From: Anita Gardner
Sent: 24 January 2019 17:41
To: Karen Parsons
Subject: FW: K/40/18/PL - Demolition of existing dwelling & erection of 1 No. dwelling, associated landscaping & parking (resubmission following K/11/16/PL)

Re: K/40/18/PL - Demolition of existing dwelling & erection of 1 No. dwelling, associated landscaping & parking (resubmission following K/11/16/PL)

- D-00 Rev A (Site Location and Block Plan)
- D-02 Rev A (Proposed Site Plan)
- D-12 Rev A (Proposed North Elevation)

Drawing: Proposed Garage Elevations
Dwg No: 247-D-15

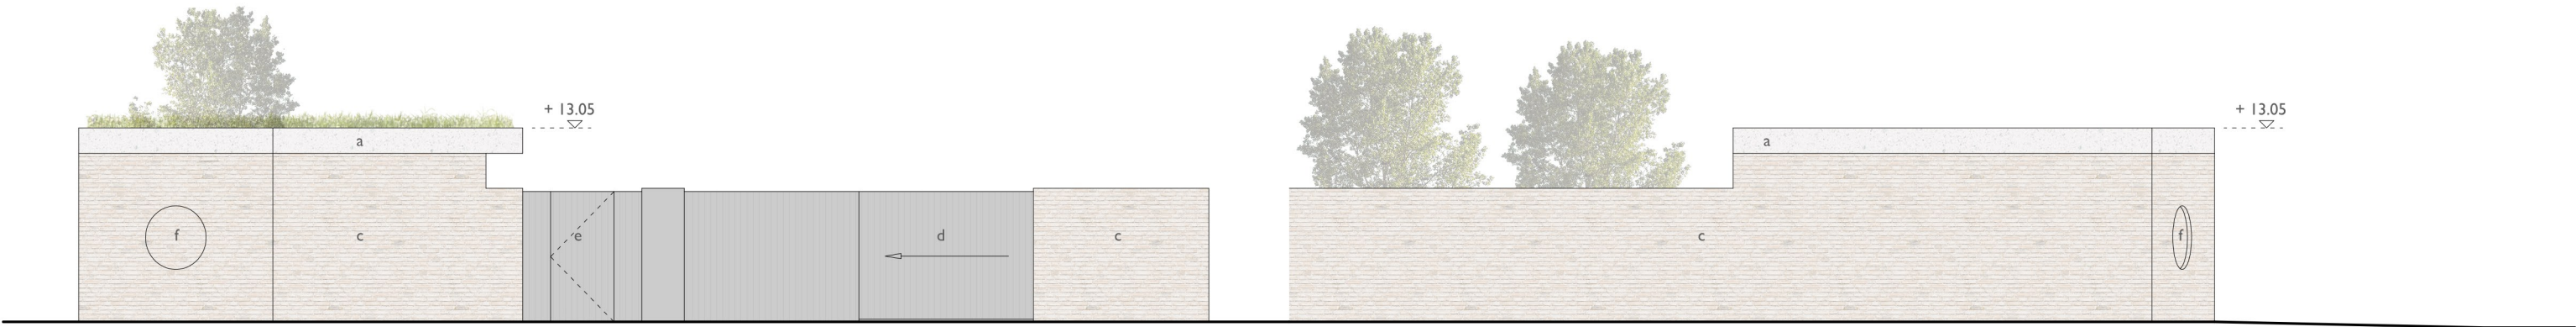
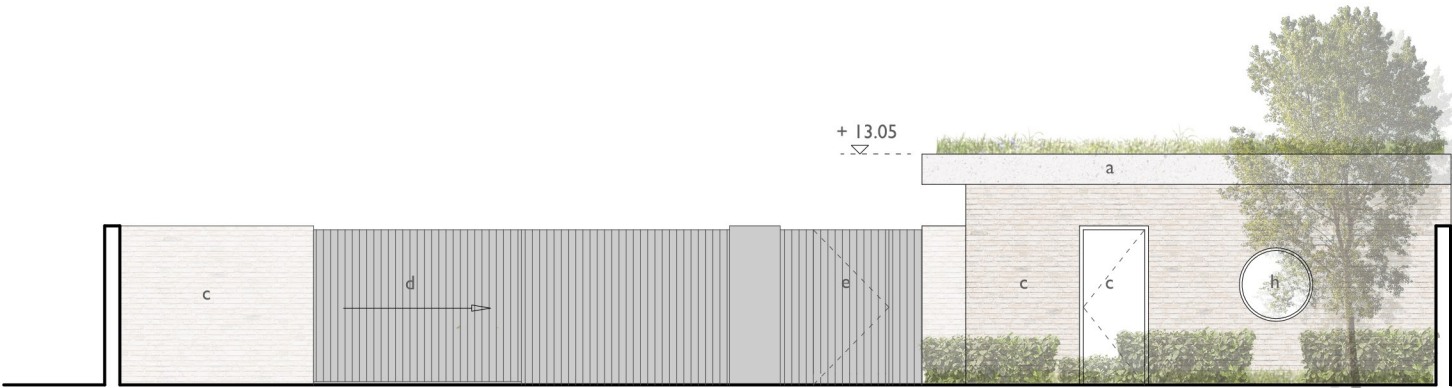
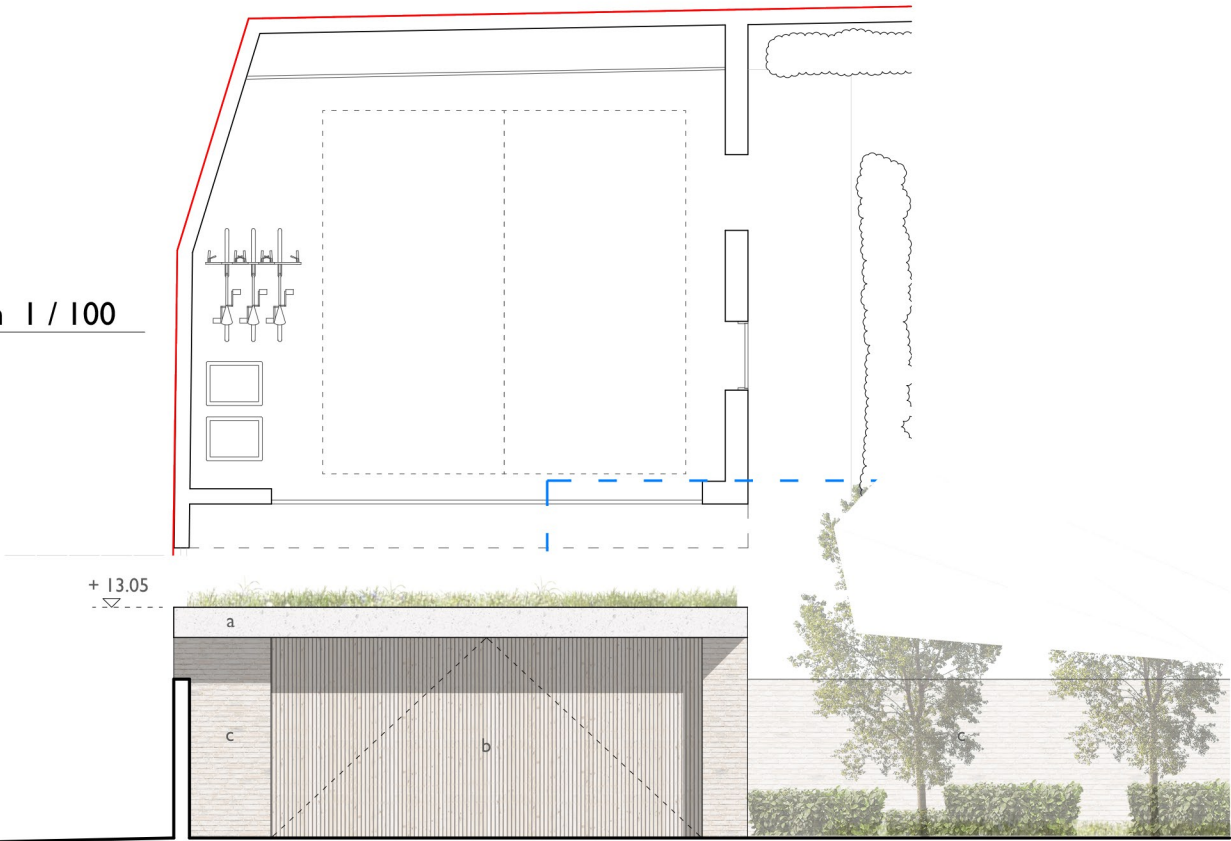
I will substitute these plans for the originals. Please can you also confirm that drawing 247-D-15 is to be deleted from the application and provide a new plans index sheet

The Board have requested that we remove the detached garage to the front of the plot and that we make the North facing window to the 2nd floor obscured.

It is hoped that with the loss of the garage, the overall footprint of the proposal is now acceptable to the Board. Whilst the single storey element stretches back towards the front of the plot, there is now no development along the front boundary and the 'internal garden' that is bounded by the single storey element is complimented by green roofs which soften the appearance of this part of the development from the only point it can be fully perceived, ie from the upper storeys of the neighbouring properties.

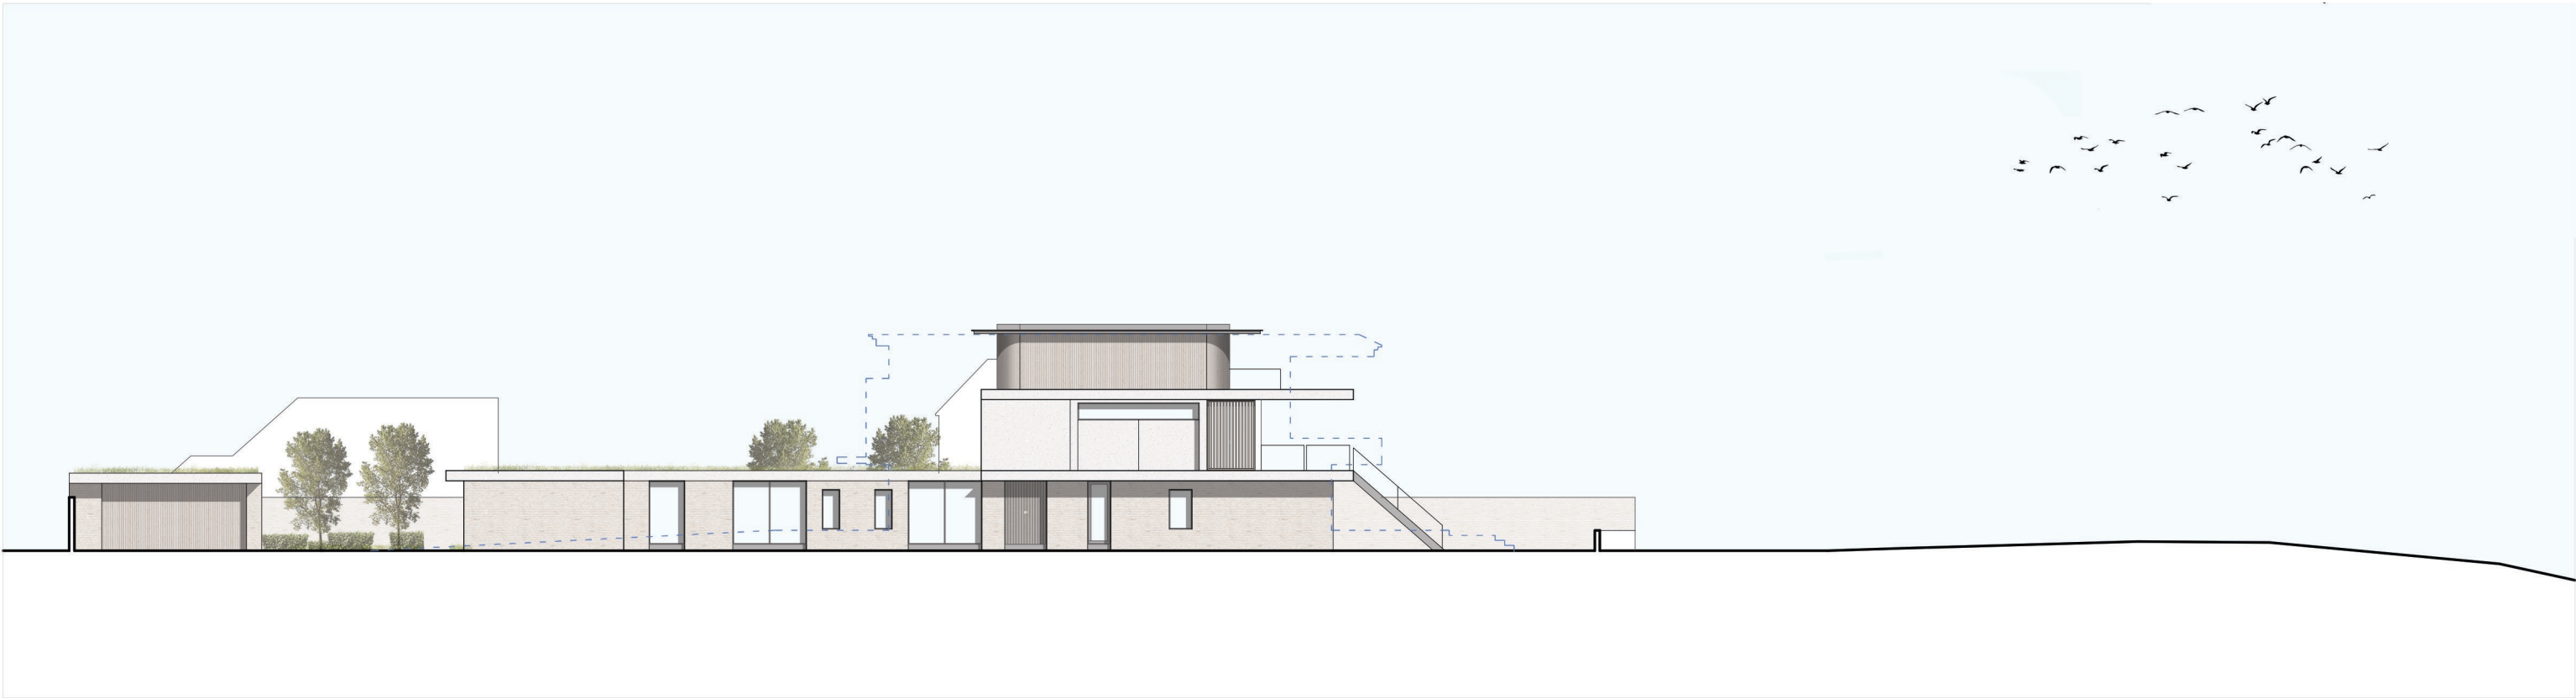
The proposal is only ever so slightly higher than the existing house and just marginally higher (100mm) than the 2018 permission for a new dwelling but it is significantly less impactful than the 2018 permission because of the shallow depth of the upper storeys (see attached application drawing D-17). This means that the impact of the proposal on the garden of *Mariners* will be very limited, in particular when compared to the extant permission. Indeed because of the siting of the main part of the building over the footprint of the existing house, there will be very little change from any shadowing that occurs at present.

Drawing: Proposed North Elevation
Dwg No: 247-D-12-REV-A

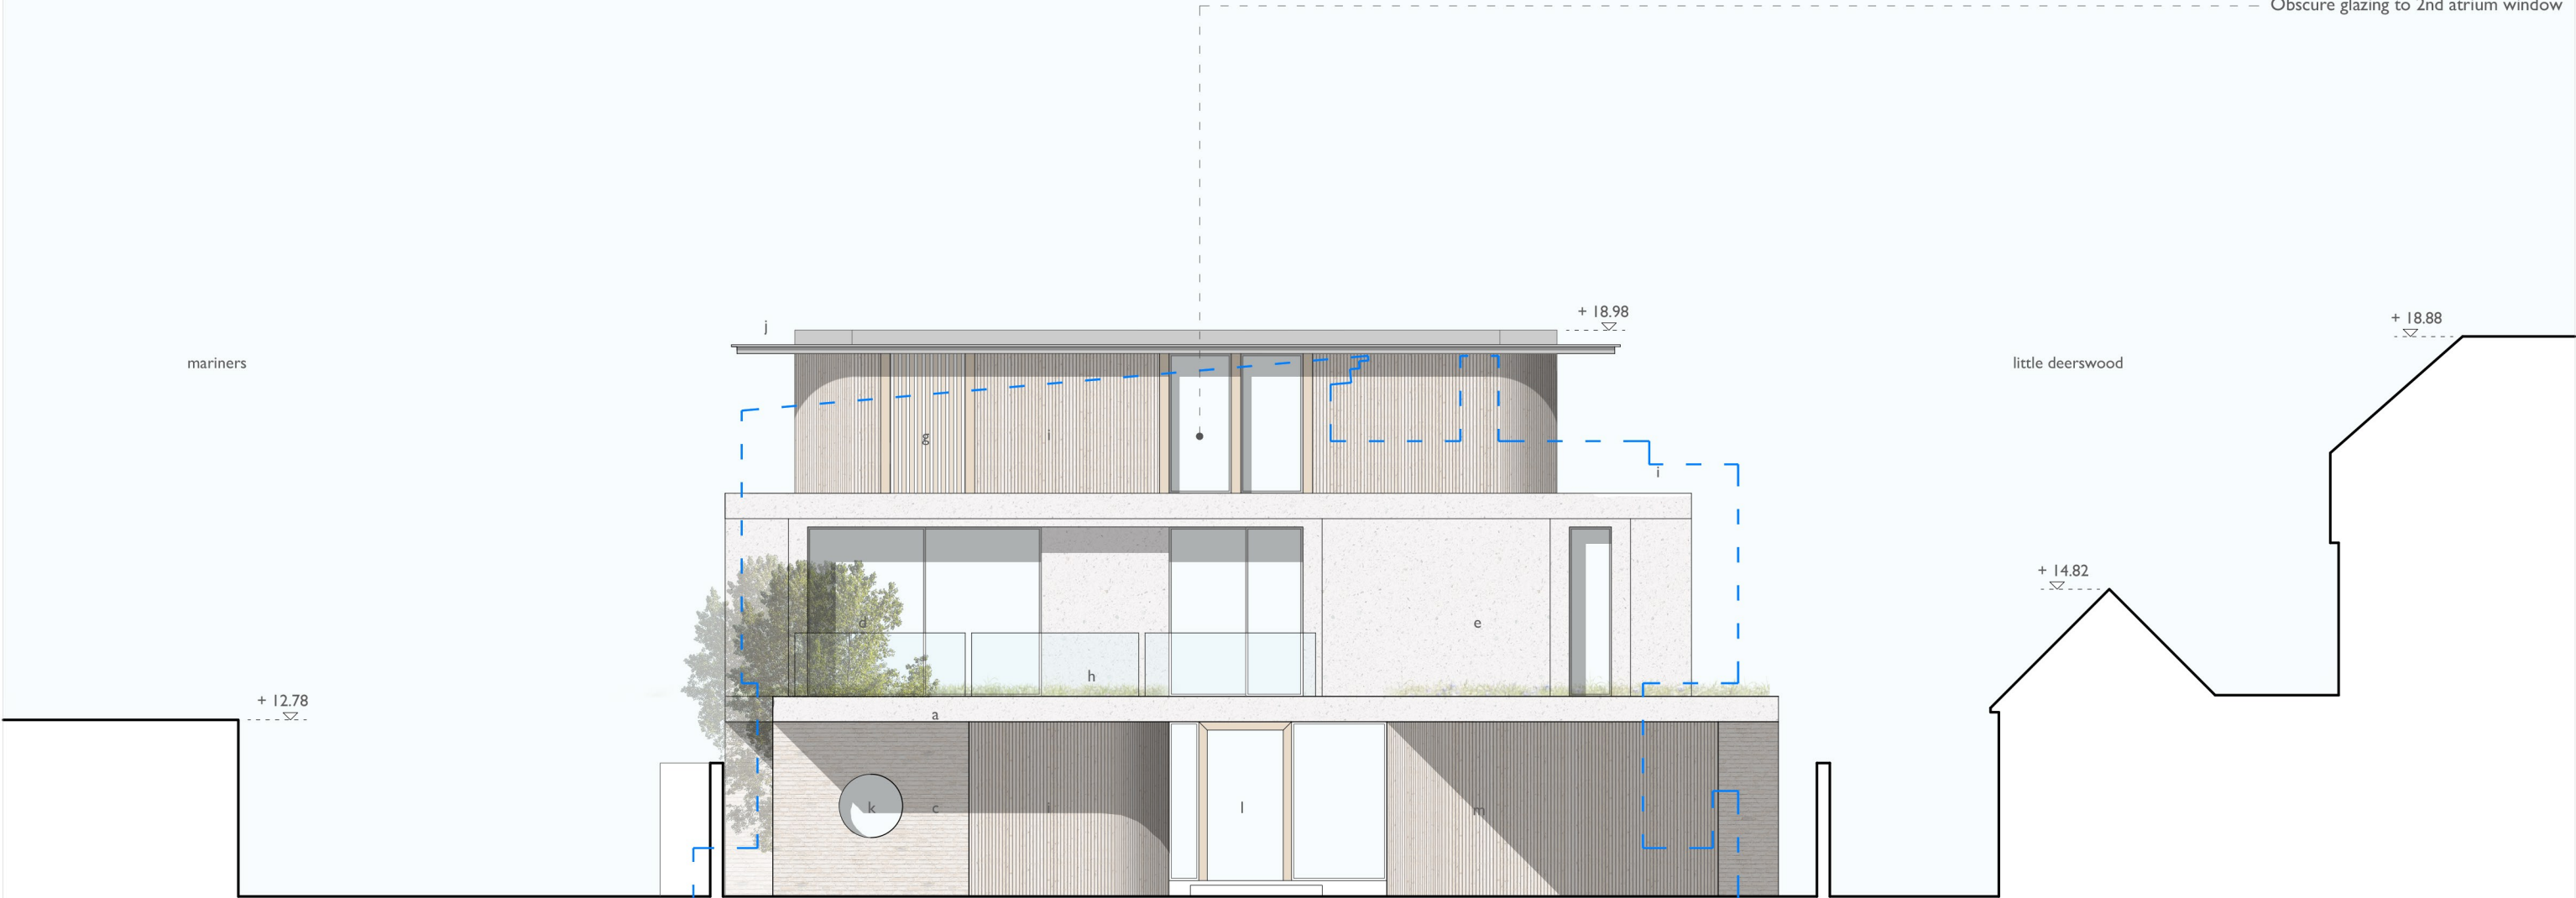
The window at 2nd floor looking to the North over Gorse Avenue is set a full 30m away from the property *Westwood*, and as we discussed on site, the views out from this window are limited as it opens out from an atrium space. However should there be a concern with the impact of this window on the houses to the North, we would be pleased to propose this as obscure glazing.
